Our Case Number: ACP-323972-25

Re: Public realm and community infrastructure project on lands in Ardee, Co. Louth
Ardee, Co. Louth

OBSERVATION IN RELATION TO THE ARDEE 2040 PLANNING APPLICATION

job number:	drawing number:	revision:
HDC1256	1006 (K)	06

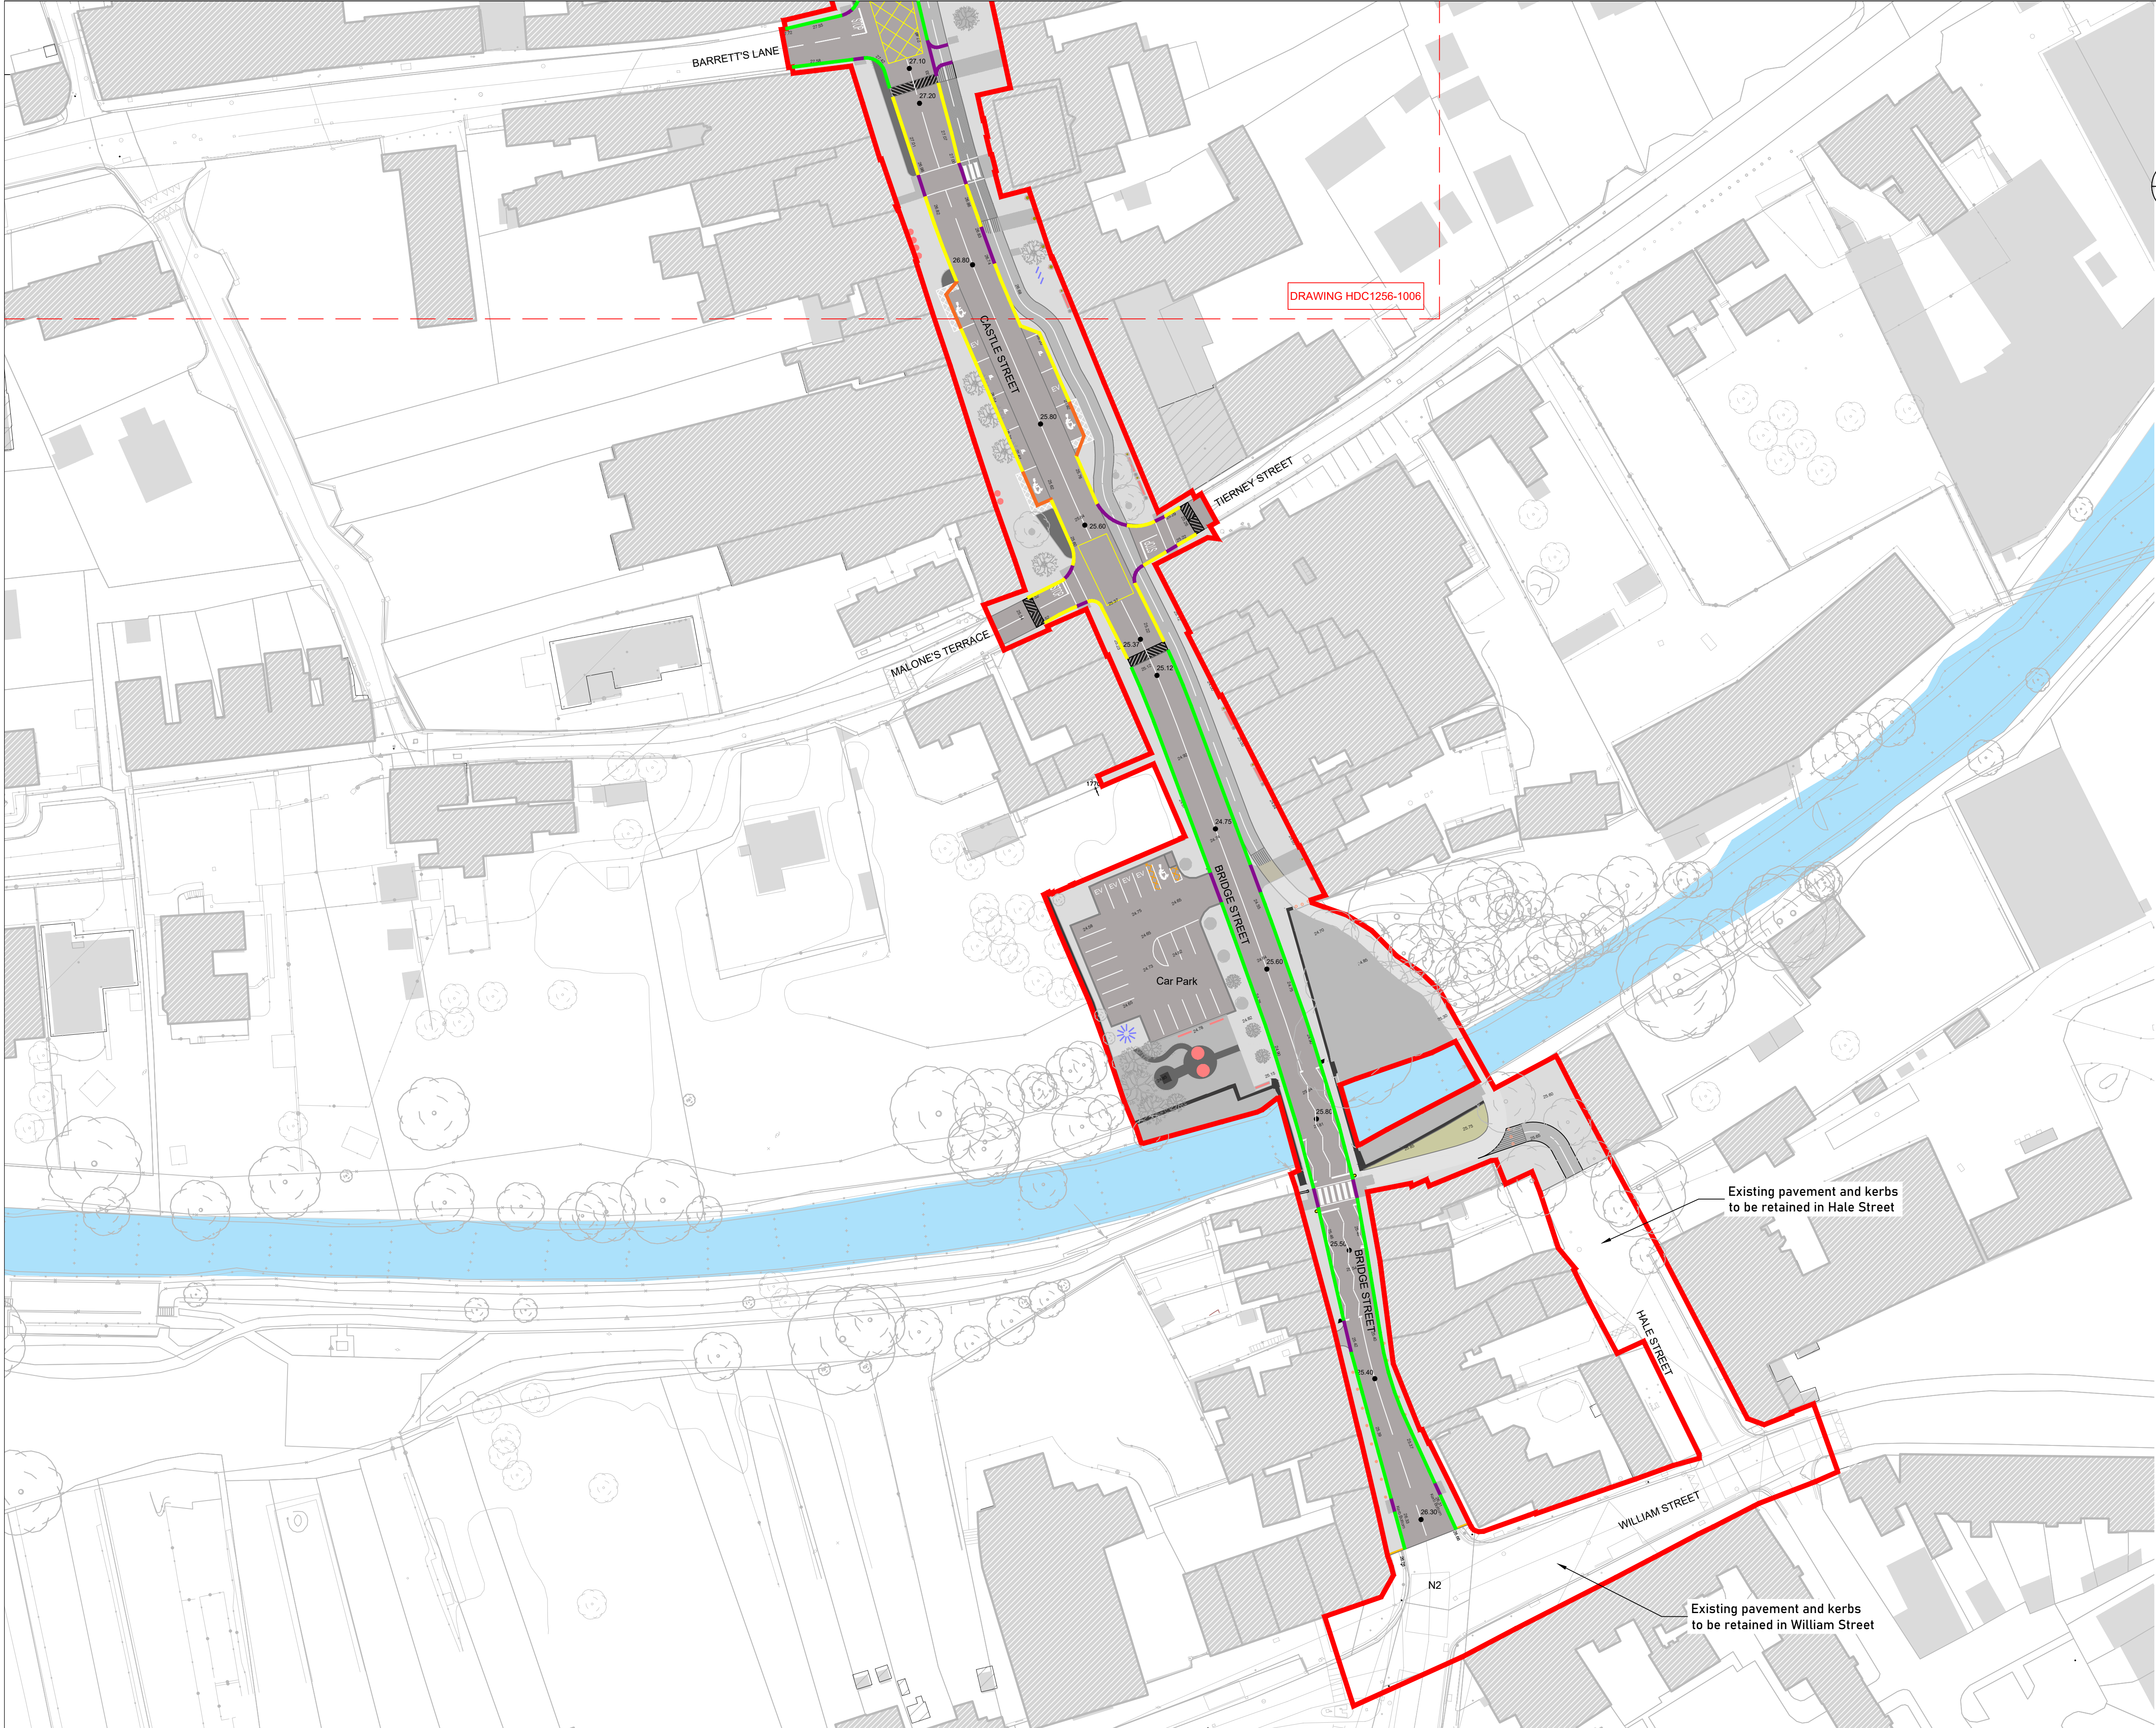
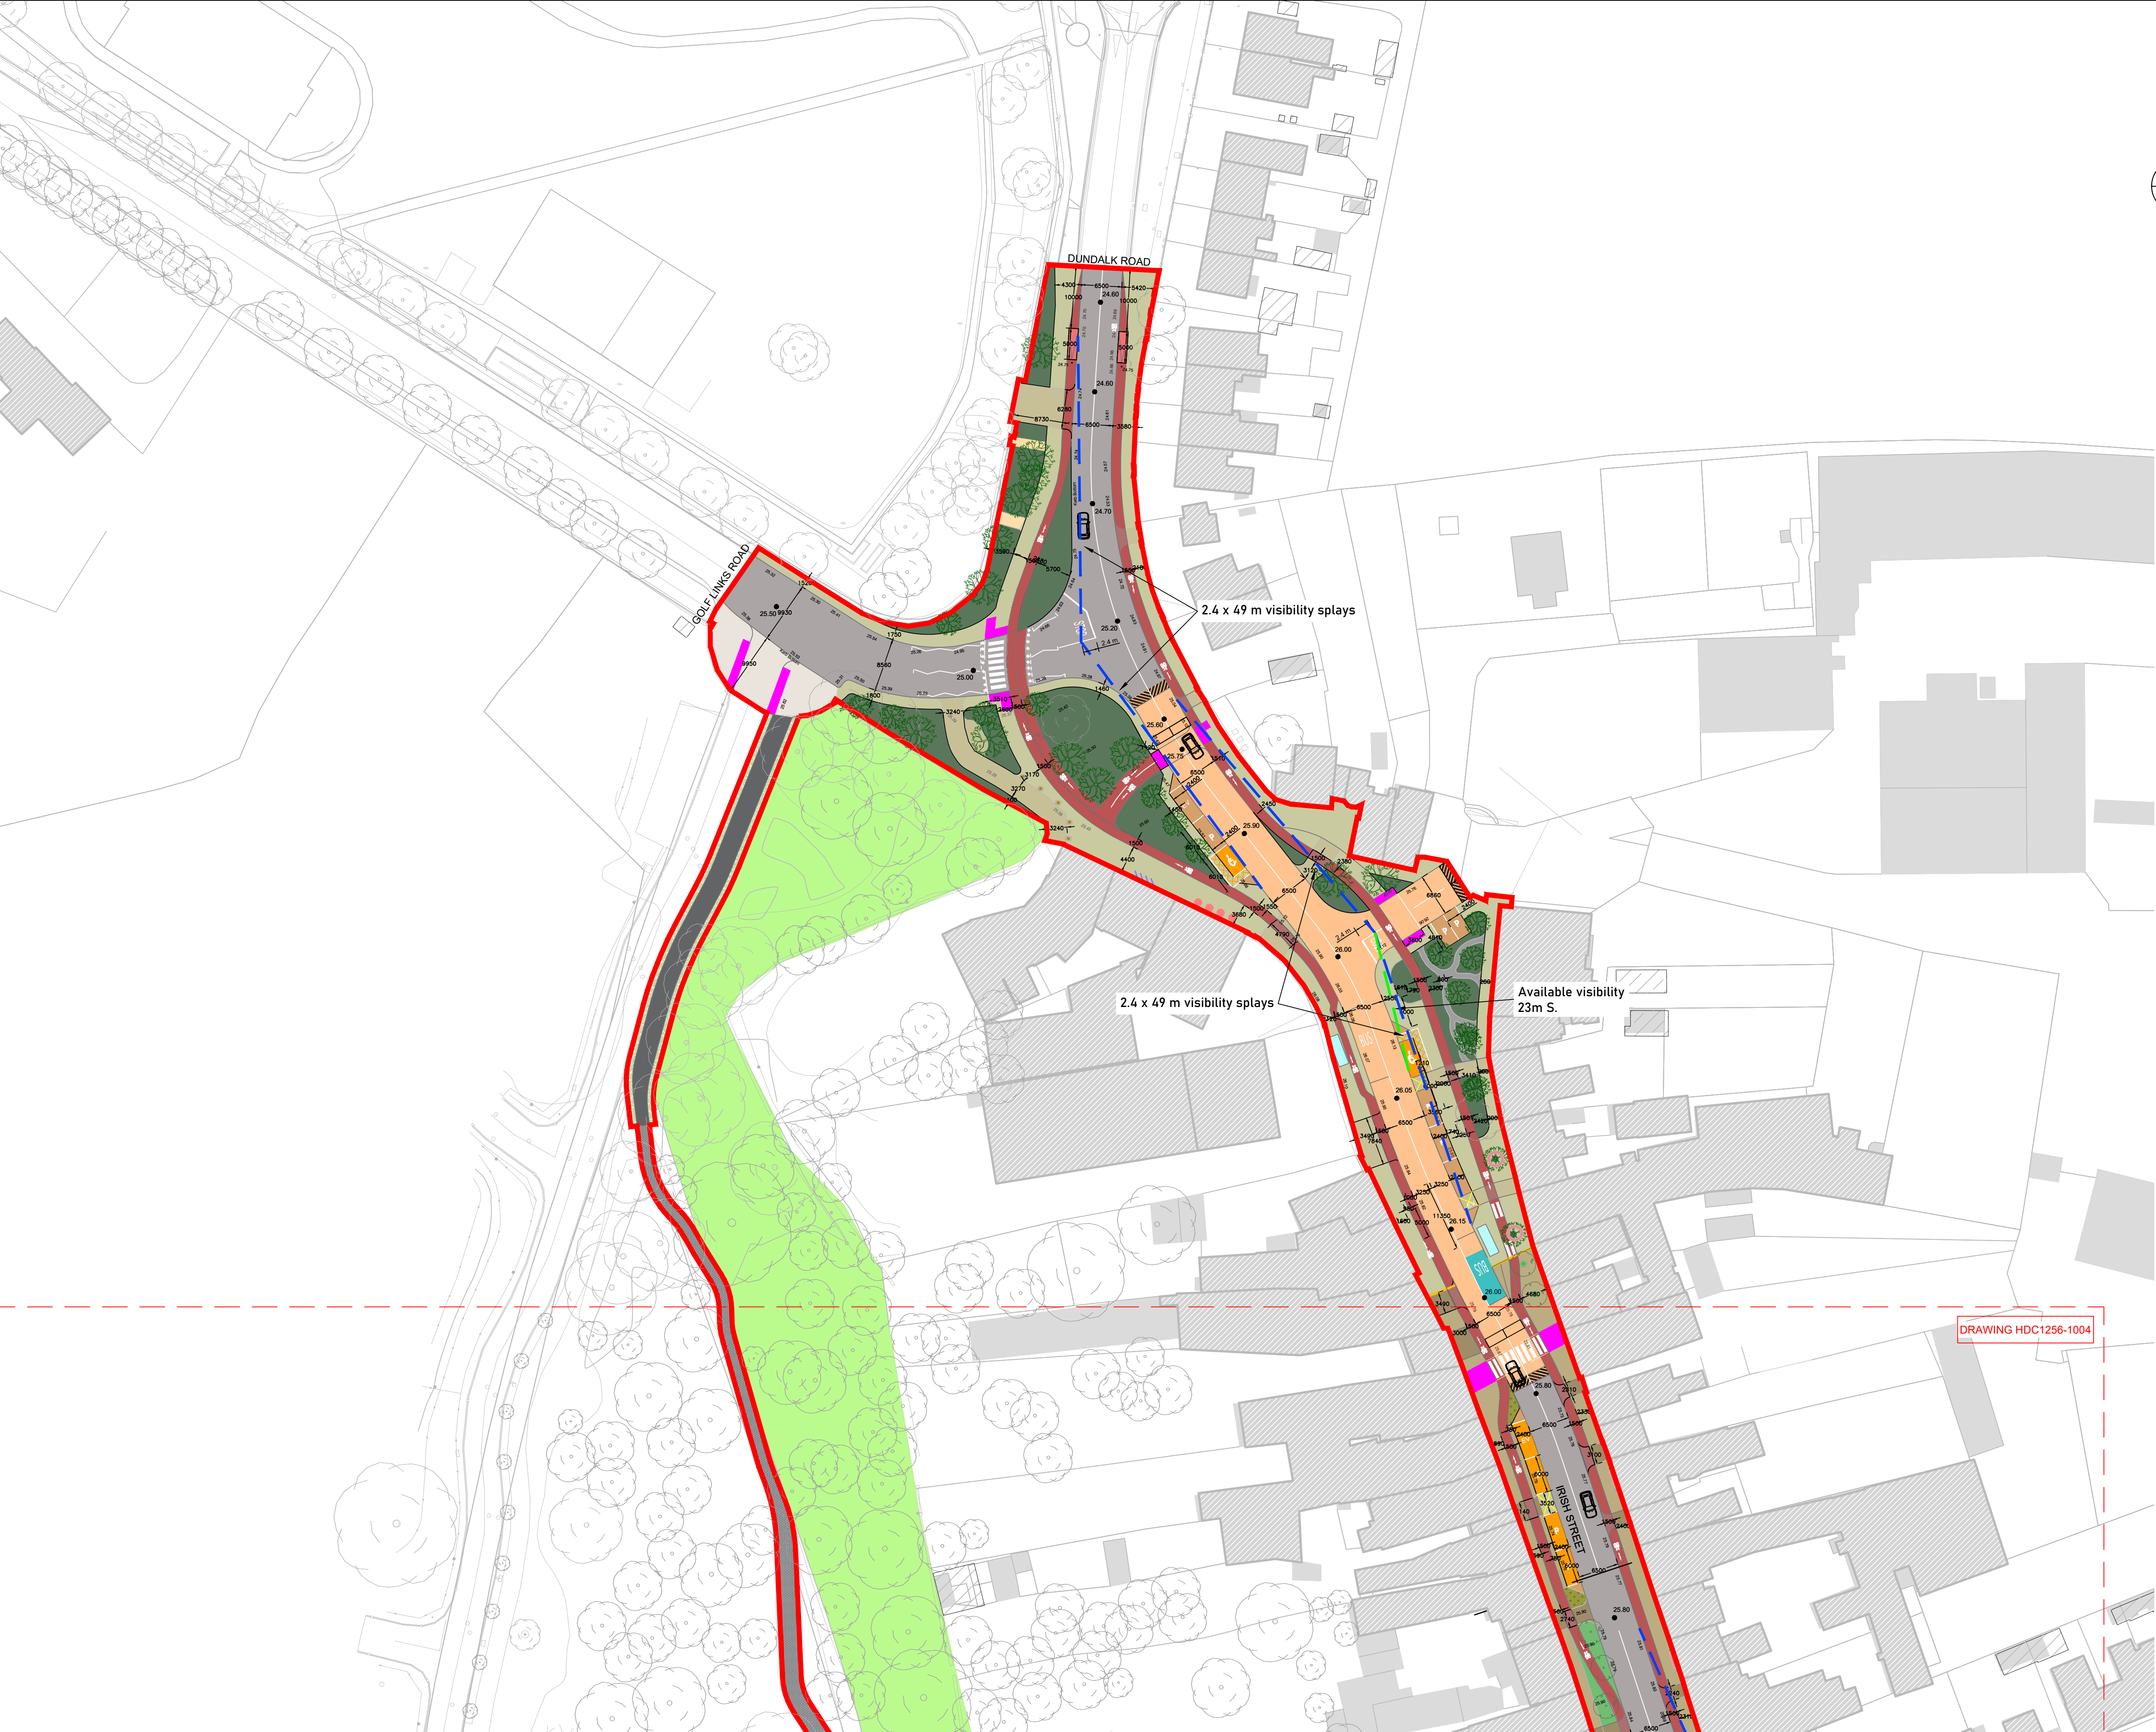
Having reviewed the proposed changes to the Irish Street area, specifically the introduction of a green space and the reduction of parking spaces on our side of the street to what appears to be no more than five (likely to be allocated to the homeowners in the area) I would have huge concerns.

The proposal, as presented, would effectively remove the practical availability of parking directly outside the property we occupy, as well as the adjacent premises which we own and lease to Ardee Jewellers. The loss of accessible on-street parking would have an immediate and detrimental impact on both businesses. In real terms, it would render the units commercially unviable.

Furthermore, the proposed layout changes appear likely to obscure our premises from clear street view. Reduced visibility, combined with the loss of parking, would severely undermine footfall and passing trade. The cumulative effect would be to place further pressure on independent businesses already operating in a challenging environment.
